**PERENCO RESPONSE TO STATEMENTS MADE BY THE APPLICANT WITHIN:
DEADLINE 4 SUBMISSION – 18.13 WAVENEY HELICOPTER ACCESS SUPPLEMENTARY ANALYSIS**

The positioning of Anatec within the “Waveney Helicopter Access Supplementary Analysis” is incorrect. The report gives the impression that Anatec are neutral reporters overseeing the Applicant’s and Perenco’s aviation specialists. The Applicant’s aviation specialist is contracted by Anatec who are contracted by Equinor.

Figure 4.4: Wind Direction Daylight Hours Per Year When IMC Minus No-Fly Points

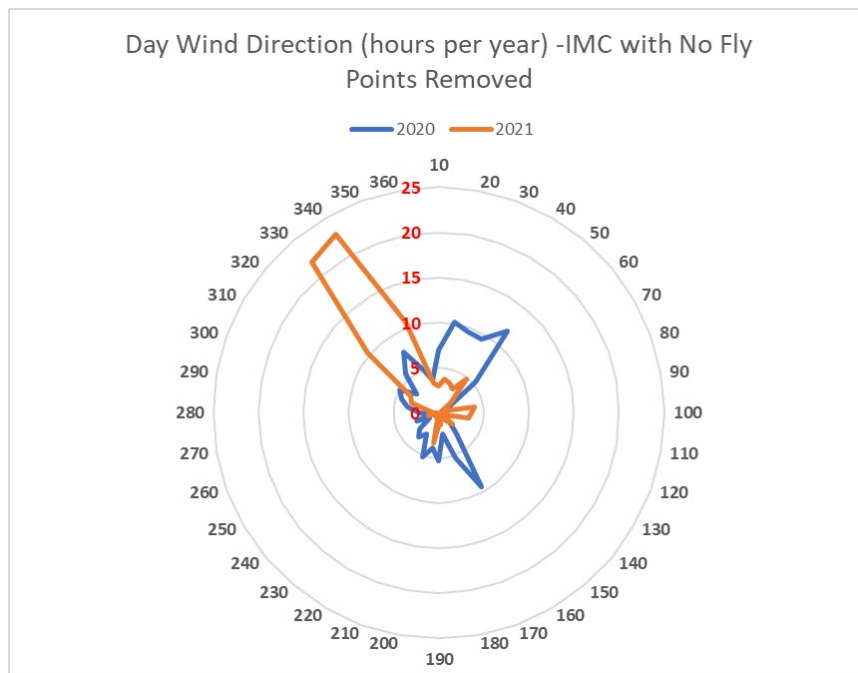
Paragraph 36	The meteorological data supplied by Perenco demonstrates that the impact of DEP on operations to the Waveney platform will be minor. See Table 3.1	Not Accepted	As set out in Figure 3 of Perenco’s ‘Technical Note on the impacts of accessing the Waveney installation with DEP turbines within 1.5nm’ (REP4-050), the likely impact of DEP on

undertaking work on the Waveney platform is not minor, resulting in losses of up to 16%.
Paragraph 37	The updated meteorological limits proposed by the CAA will only have a minor impact of day access to the Waveney platform. For example, the day VMC access in 2021 reduced from 94.5% to 93.3%.	Not Accepted	As set out in Figure 3 of Perenco's 'Technical Note on the impacts of accessing the Waveney installation with DEP turbines within 1.5nm' (REP4-050), the likely impact of DEP (which arises primarily from the reduction in day VMC access under the updated meteorological limits proposed by the CAA) on undertaking work on the Waveney platform is not minor, resulting in losses of up to 16%.
Paragraph 38	The existing Dudgeon wind farm has wind turbines within 3nm of Waveney. If the CAA implements their draft regulations in full, then all future flights to any helideck located over Waveney will be day VMC only (including any NPI operations). In this case DEP will have no additional impact on night operations, as they will already be forbidden. The CAA may issue a helicopter operator with a dispensation from the regulations, when supported by a safety case. If a dispensation is provided, then some limited night operations to a helideck at the Waveney site may be possible.	Accepted	Given that there is only a single wind turbine within 3nm and it is nearly 3nm away, it is highly likely that the CAA would grant a dispensation such that the anticipated new rules concerning flights within 3nm of a windfarm would not preclude night flying to Waveney, other than within the existing limitations of night flights.

**Figure 3.1 Proximity of Dudgeon Wind Farm Turbines to the Waveney Platform**

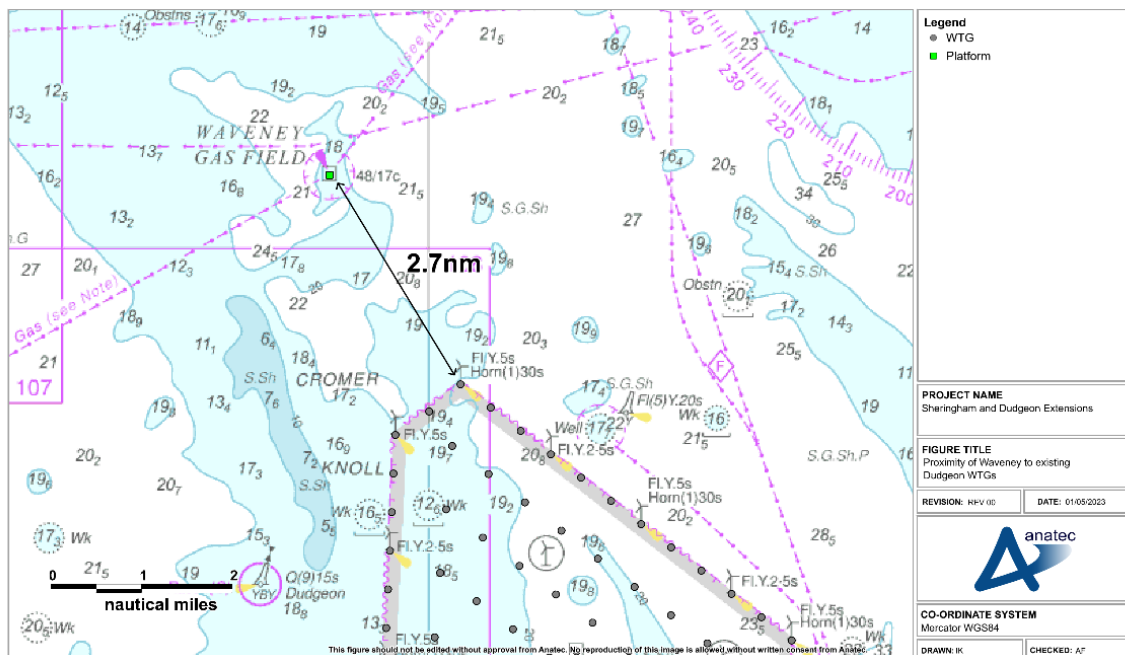
<p>Section 3.2.1, Paragraph 32</p>	<p>Historically, the CAA has provided dispensations to operators, providing they are supported by a safety case. Based on previous cases, it is possible that the CAA will provide a limited dispensation for night operations.</p>	<p>Accepted</p>	<p>Given that there is only a single wind turbine within 3nm and it is nearly 3nm away, it is highly likely that the CAA would grant a dispensation such that the anticipated new rules concerning flights within 3nm of a windfarm would not preclude night flying to Waveney.</p>
<p>Section 3.2.2, Paragraph 33</p>	<p>Potential Night Operations Under a CAA Dispensation If a dispensation from day only operations was granted by the CAA, then some limited night operations might be possible to an NPI located at Waveney. It was agreed that, subject to a CAA dispensation, approaches when the wind was from 110° clockwise to 240° could be conducted safely. These approaches would be flown into wind, i.e. from the reciprocal of the wind direction, and permit a night stabilised approach point at 2nm or greater. The</p>	<p>Accepted</p>	<p>Perenco shares the Applicant’s view, as set out in Paragraph 33 (Section 3.2.1), that following construction of DEP night operations to a non-producing installation (NPI) at Waveney may be a restricted to when the wind is from 110° clockwise to 240°. For the avoidance of doubt, this restriction would not apply prior to construction of DEP.</p>
